From: Stuart Corbey
Sent: 03 October 2018 14:32
To: Planning.Responses
Subject: FW: Planning Application - LU/201/18/PL - 137 Bayford Road - house of multiple occupancy

The Licence (issued to Imperial Portfolios Limited) is for 15 persons in total but dependent upon the following works being completed:

HMO PLAN

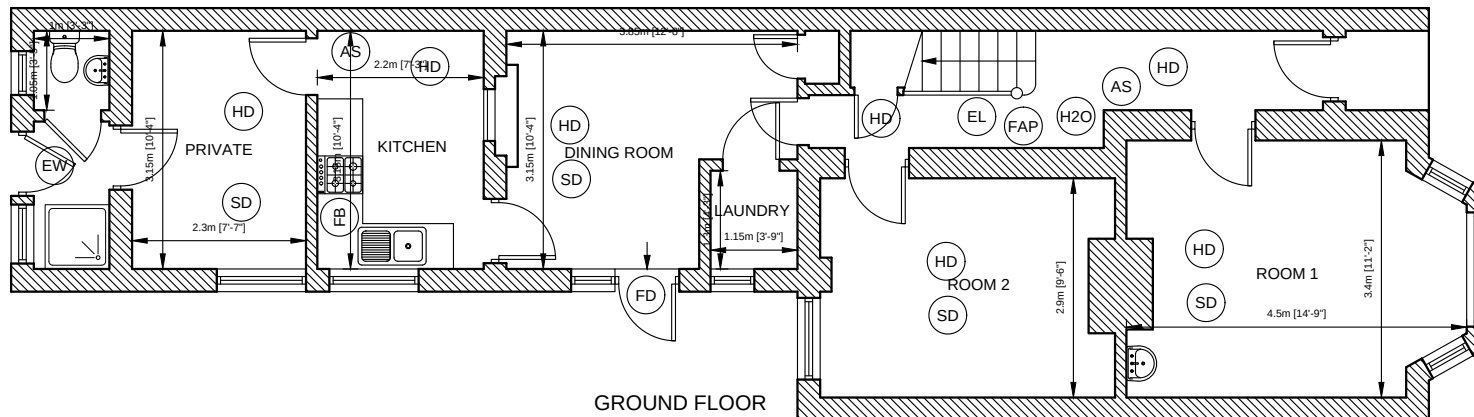
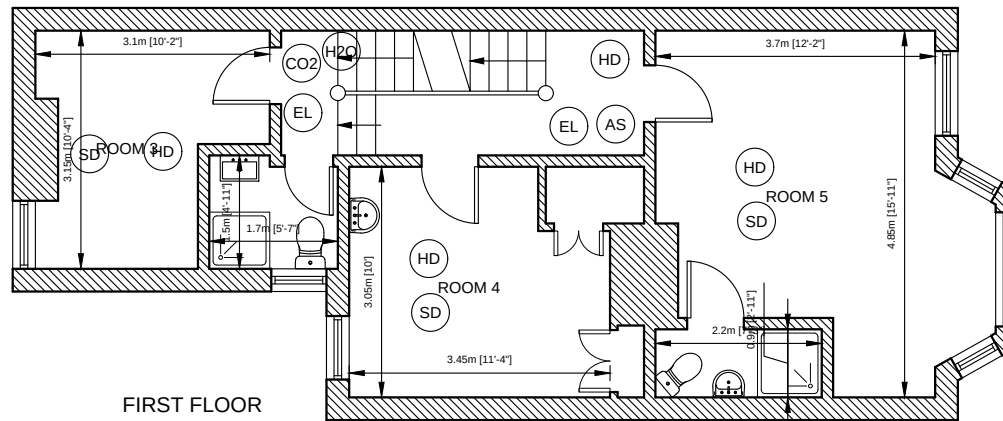
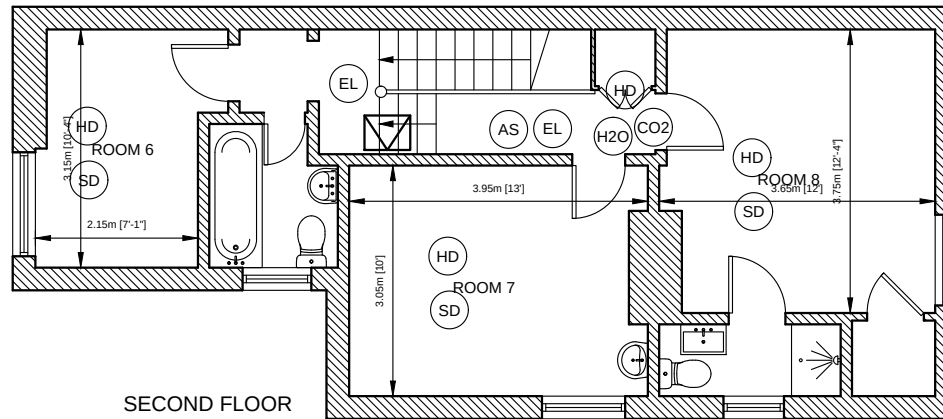
Condition	Date for Compliance
23.	Room Sizes <u>At the current time the property is only suitable for occupation by a maximum of five (5) persons due to the lack of sufficient kitchen and bathroom facilities.</u> To increase the number of occupants that can reside within the property the following facilities will be required: <u>Kitchen & Dining Area</u> – The kitchen only measures approximately 7.07m² and is therefore undersized for the number of intended occupants. The dining area measures 10.4m².	14th November 2018

The current shower-rooms are very small and provide only a minimal amount of circulation and drying space.

Bedroom 1 – max. 2 persons;
Bedroom 2 – max. 1 person;
Bedroom 3 – max. 1 person;
Bedroom 4 – max. 2 persons;
Bedroom 5 – max. 3 persons (en-suite);
Bedroom 6 – max. 1 person;
Bedroom 7 – max. 2 persons;
Bedroom 8 – max. 2 persons (en-suite);
Bedroom 9 – max. 1 person (en-suite).

The total number of occupants for the property however, based on the current bathroom and kitchen facilities and communal living space, is five (5) persons. Additional kitchen facilities are required for more occupants than this. It is likely that to be able to provide a sufficient amount of communal space (needed due to the smaller sizes of some of the bedrooms), kitchen facilities (additional sink and cooking facilities) and bathroom facilities (i.e.

additional separate WC with wash hand basin), a change in layout (or reduction in intended number of occupants) will be needed.	
24.	All hallways and landings are required to have heating provision. The ground floor hallway has a radiator; however the first floor and second floor landings do not and unless it can be shown that the ground floor radiator is sufficient to heat the first and second floors as well, additional heating will be needed. This would be best achieved by extending the gas central heating system; however if this is not possible electric heaters with timing and temperature controls are required. All electric heating must be fuse-spurred into the electrical system and not just plug-in. All heating in hallways, whether gas or electric, must be capable of reaching and maintaining +18°C when the external temperature is -1°C.	14th November 2018

25.	Both communal shower rooms only have heated towel rails provided as a source of heating. All bathrooms require suitable heating that is capable of reaching and maintaining +22°C when the external temperature is -1°C.	14th November 2018

26.	Mechanical extract ventilation to the open air is required in the first floor and second floor bathrooms. This will need to have an extraction rate of at least 15 litres per second.	14th November 2018

27.	Mechanical extract ventilation to the open air is required in the kitchen. It could not be confirmed that the extractor in the kitchen vents to the outside air. This will need to have an extraction rate of at least 30 litres per second if it is adjacent or above the cooker/hob and 60 litres per second if located elsewhere in the room.	14th November 2018

28.	All Lounges and Dining rooms must have a minimum of three (3) double electrical sockets. Only one double could be seen in the communal dining room.	14th November 2018

29.	All hallways/landings must have a minimum of a single electrical socket. The ground floor hallway has no socket provision.	14th November 2018

30.	The two communal shower rooms both only contain cloakroom-sized wash hand basins. Minimum wash hand basin sizes are 560mm x 430mm. Cloakroom-sized wash hand basins are acceptable for rooms containing a WC only.	14th November 2018

31.	The en-suite bathrooms in Bedrooms 5, 8 and the caretaker's bathroom only have cloakroom-sized wash hand basins. Minimum wash hand basin sizes are 560mm x 430mm.	14th November 2018

32.	The property is short on bathroom facilities and lacks a separate WC with wash hand basin (see requirements in item 23 above).	14th November 2018
33.	There are insufficient kitchen facilities for the proposed number of occupants. The current provision is only suitable for a maximum of five (5) persons: a. There is only a single sink and drainer; b. There is only a single four-ring hob and cooker; c. There is insufficient cupboard and drawer storage space for the number of intended occupants; d. A minimum of three (3) double electrical sockets are required above the food preparation surface (as well as dedicated sockets below worktop level for white goods).	14th November 2018
